City of Albuquerque

**Re: Justice Systems Inc Remodel, 4600 McLeod Road NE, Traffic Circulation
Layout**

Architect's Stamp dated 4-11-05 (F17-D29)

SITE PLAN, INDEX, VICINITY MAP
SHEET NO.
A1
JOB NO. : 05-104 OF 7

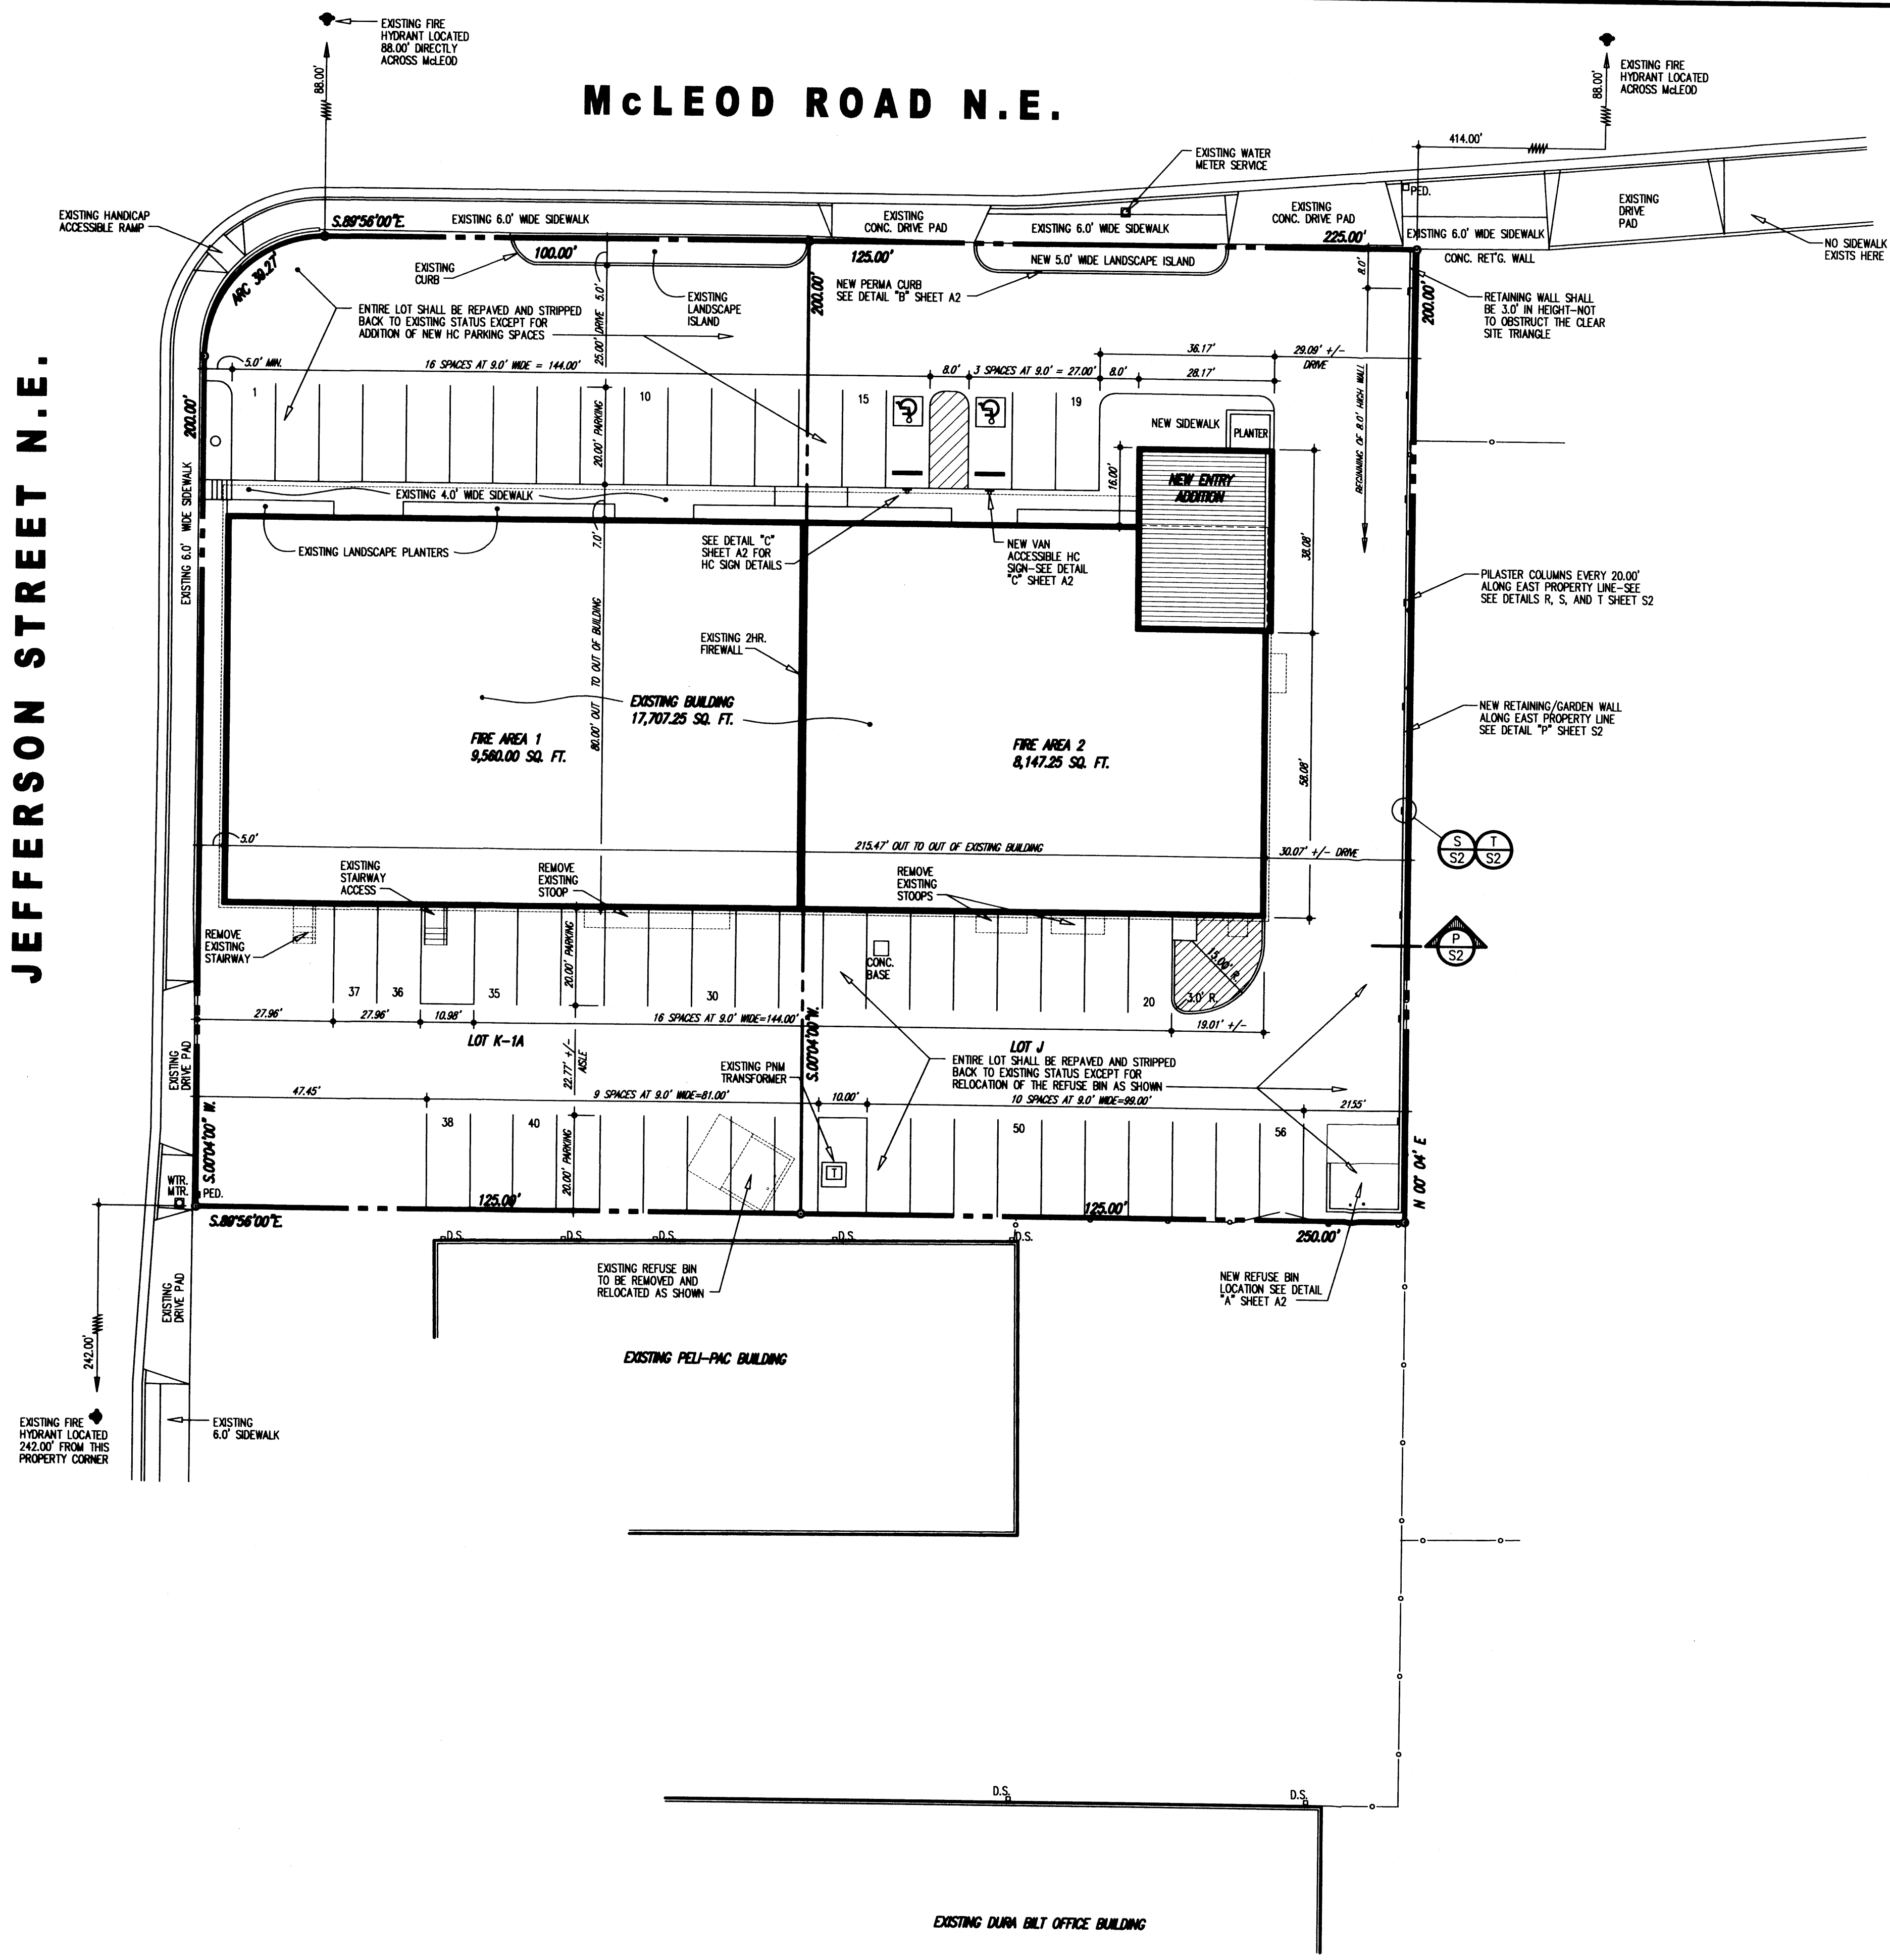
- Please note that the 2-foot overhang is not allowed to encroach on the 6 foot required width of sidewalk. Also, all standard parking spaces have a minimum length of 18 feet. Therefore, the sidewalk can be 8 feet wide with a 2-foot overhang, or the parking spaces must be 20 feet in length with bumpers.
